Mr Rodger Roppolo
Department of Planning and Environment
PO Box 32
PARRAMATTA NSW 2150

16 February 2023

RE: Notice of Exhibition – Open Water Surf Facility – Modification 2 (SSD-7942-MOD 2)

Figure 5: Comparison of the events lawn as approved and as proposed to be modified.

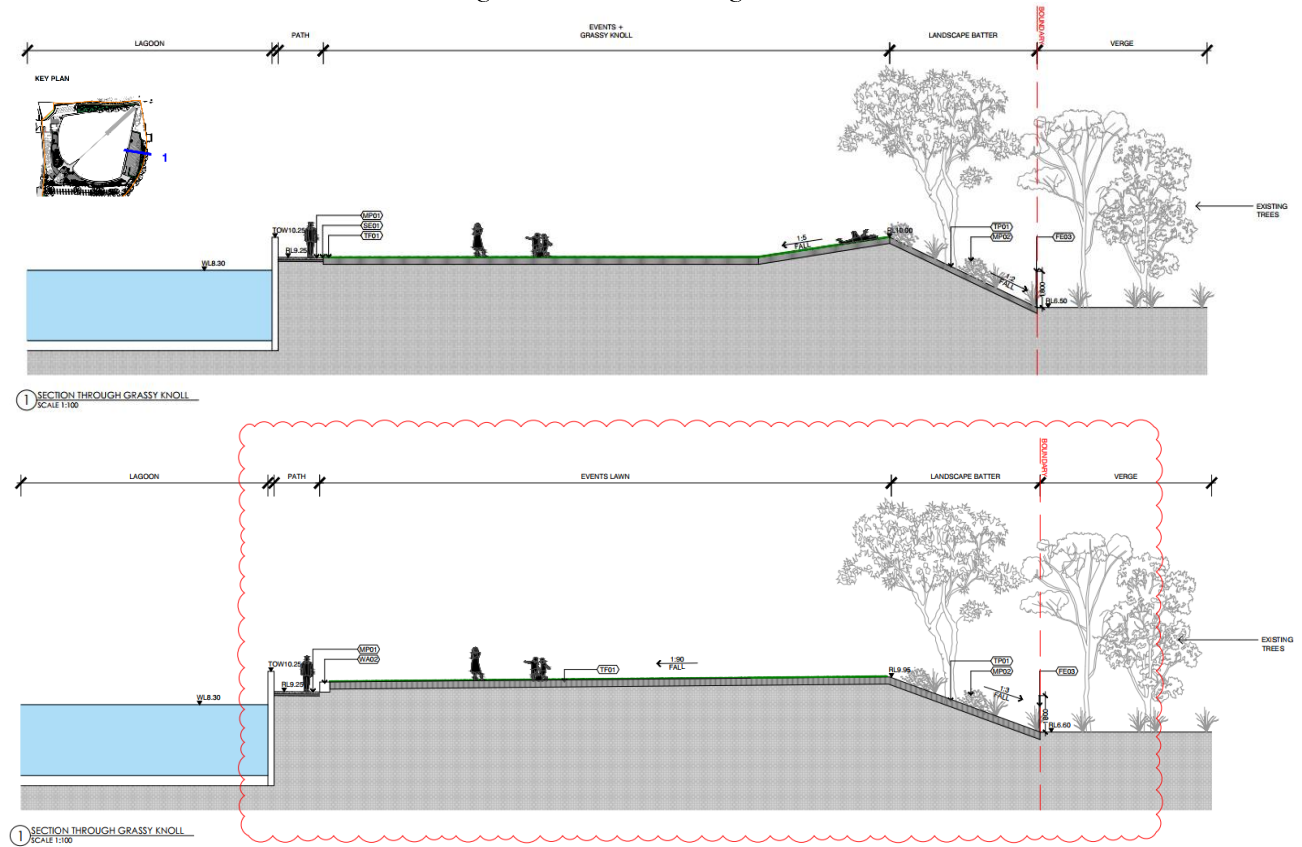
In relation to the Remediation Action Plan, the Modification includes reducing the approved capping over asbestos contaminated areas from 300mm plus 200mm top soil to only 300mm in total for the public lawn and landscape areas. It is noted that to mitigate the potential for reduced durability, the alternative design proposes leveling off of the landscape areas to a maximum slope of 1:3. This will increase the durability of the proposed capping. Sandstone blocks are proposed to be strategically used to reduce slope gradients of turf and planted areas. These measures will help to increase durability of the surfaces from erosion.

Despite the above, the key remediation principal for the asbestos waste is based on a cap and contain system and therefore the integrity of the capping is critical in minimising risks. A 300mm capping profile is much shallower than standard capping applications (NSW EPA prescribes 1M of capping above asbestos waste) and while SOPA recognises that the Site Auditor has endorsed the RAP and that a Long-Term Environmental Management Plan will be developed and implemented as a condition of lease, the durability of the events lawn and

landscaped areas may not be sufficient to prevent a breach of the capping which would result in exposure of the public to asbestos waste. The events lawn and landscaped areas will be used by families and children who may dig into turf or landscape areas exposing wastes and planted areas can expose asbestos wastes as trees and shrub grow and bringing asbestos materials to the surface.

SOPA recommends that the proponent give consideration to a deeper capping layer on the area of the events lawn and landscaped areas and / or the use of a more durable solution that will further reduce this risk.

Figure 6: Comparison of the landscaped batter adjoining Hill Road as approved and as proposed to be modified.

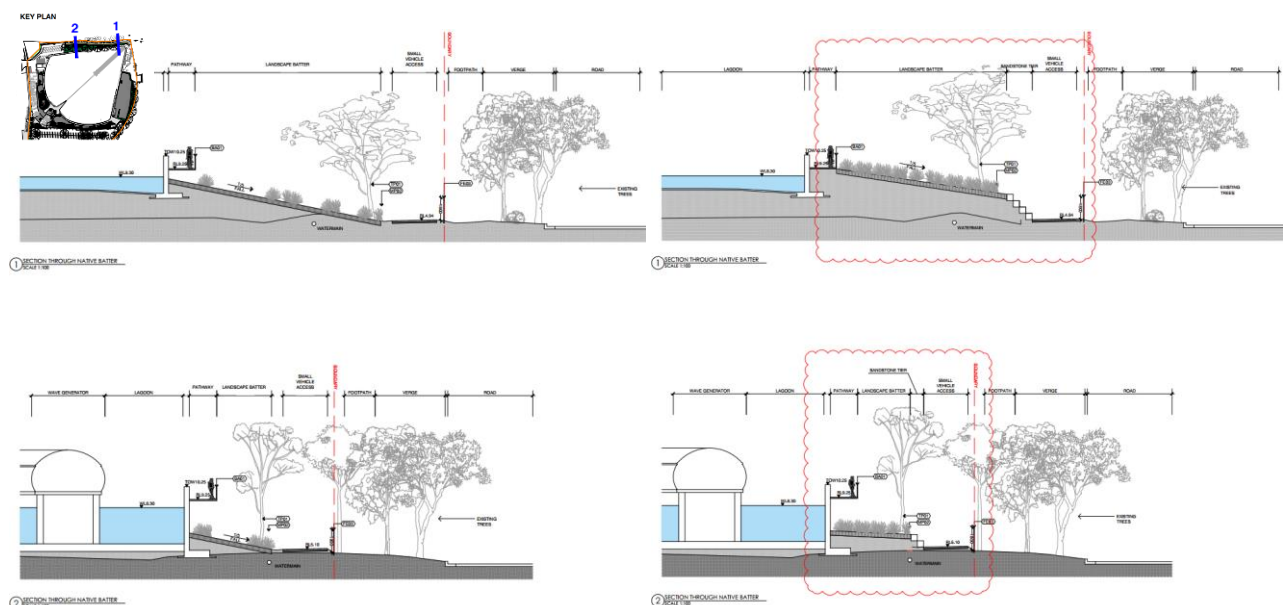
The Statement of Support document notes the proposal includes 'minor ancillary changes to soft landscaping along the Hill Road and carpark ring road boundaries' (s3.1.2). There does not appear to be a landscape plan included with the documents to detail what these 'minor ancillary changes' might be. As this change relates to the interface with SOPA land, the look and feel of the interface needs to be agreed with SOPA. Such landscaping details should be provided and agreed to by SOPA.
